Proposal: Discharge of Conditions 5 (Landscaping Scheme) and 12 (Travel Information Pack) of 15/01267/REM

- 1.4. The parent permission (15/01267/REM) to which this application relates, comprised a reserved matters submission for 44no residential dwellings, garages, highway works, boundary treatments and associated works on land adjacent to Camp Road and Gordon Road.

DATE: 21 March 2023

DRAWN BY DW	DATE 03.07.15	DRAWING NO. HEYB6.B2B-03-100	REV F
SCALE: 1:200 @ A0	CHECKED/DATE

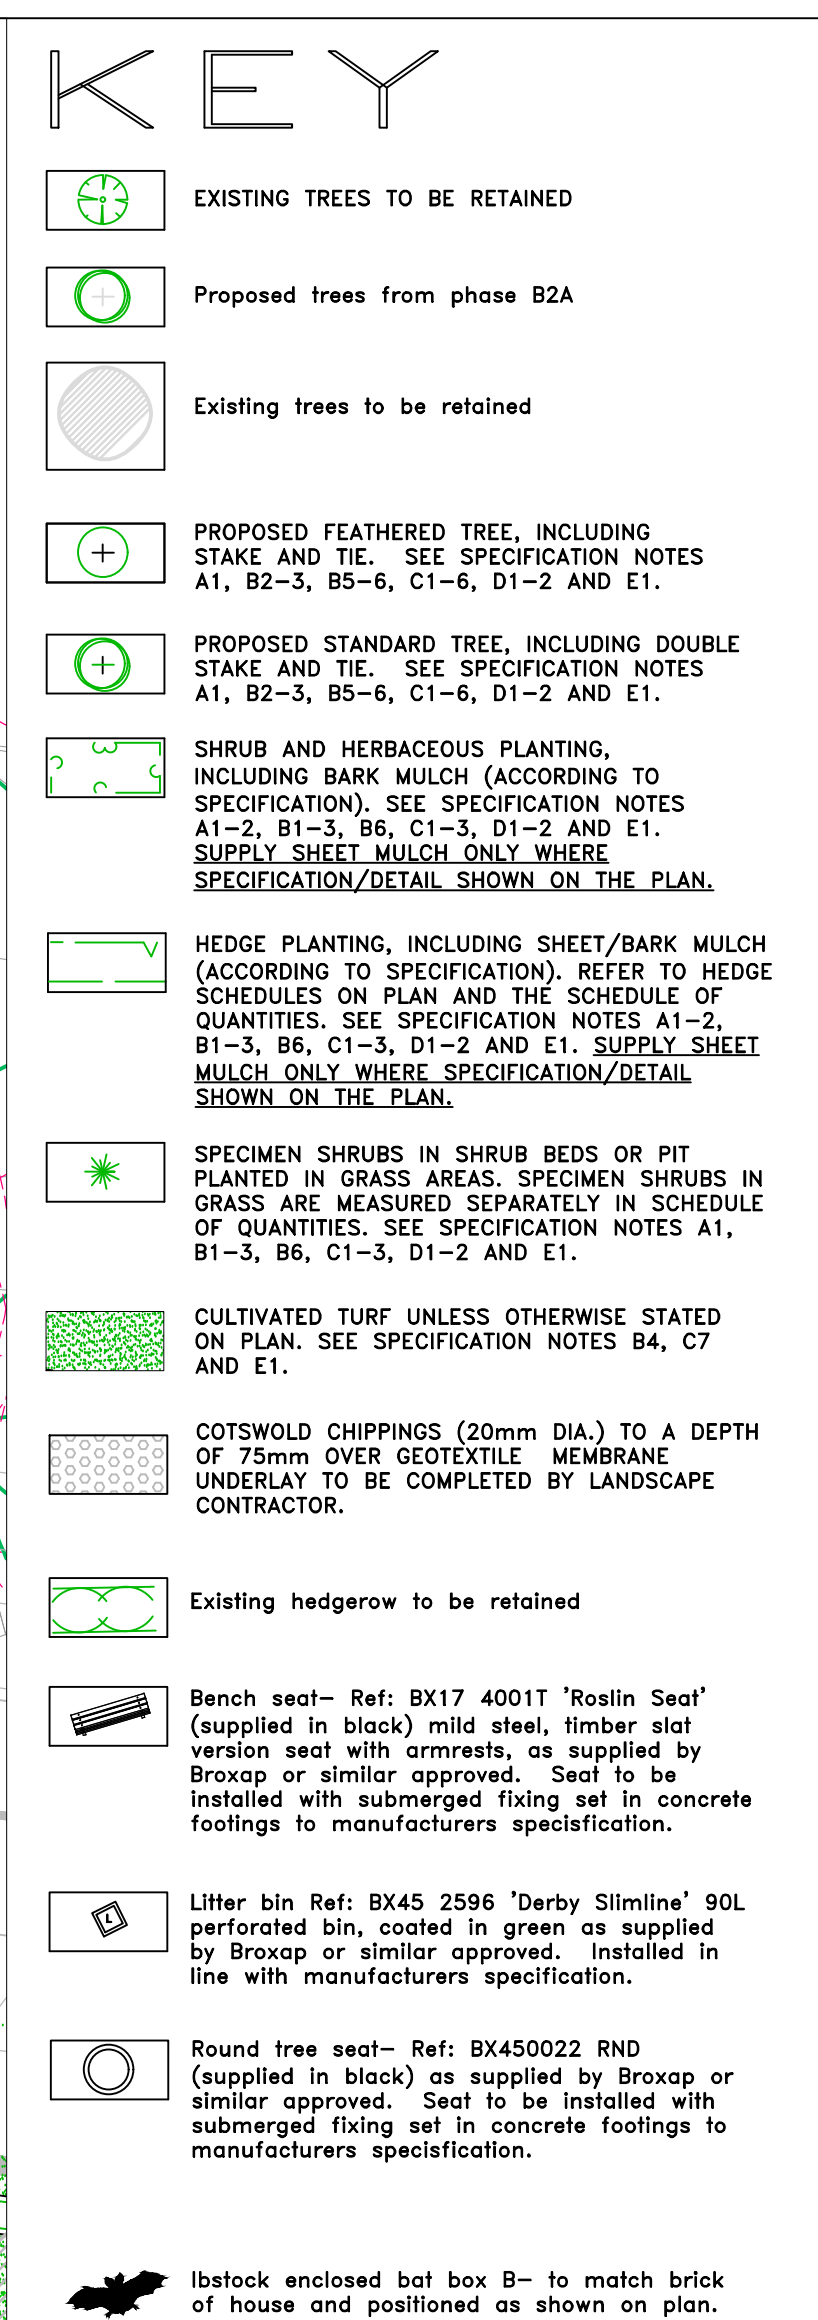
Hedges - formal hedges against walls should be assessed by structural engineer; and, may be wise to delete sections of hedges which impinge on walls.

Trees – tree pit details necessary; trees to be minimum size of 14-16 cm girth for the initial visual impact; 8-10 cm girth trees are too small for the public realm but acceptable for rear gardens; and root deflectors should be indicated.

'Since the landscaping has been implemented in accordance with the landscape proposals I feel it unnecessary to formally object. However there is concern about the tree planting close to dwellings, paving/kerbing, and whether root deflectors have been installed. Any potential light reduction to rooms, structural damage to foundations is at the developer/ManCo's risk, which may result in the removal of trees (requiring replacements in open space where appropriate): an event that will require prior consent in writing from this council.'

- (c) details of the hard surface areas, including pavements, pedestrian areas, reduced-dig areas, crossing points and steps.
- 5.3 It is noted that the landscaping scheme, as submitted and superseded by Rev G (received on 10 March 2023 – landscaping added to frontage of plots 296-298) has now been largely implemented on site and does not include the revisions recommended within the original CDC Landscape Services consultation response. However, the core requirements (i.e. to ensure the creation of a pleasant environment) of the landscaping scheme, as set out under Condition no5, have been delivered. If through the passage of time, elements of landscaping require attention, need to be removed and/or to be replanted to better respond to their built or landscape context, the LPA are able to exercise a degree of control (i.e. written approval required) – as set out under condition no7 to the parent permission.
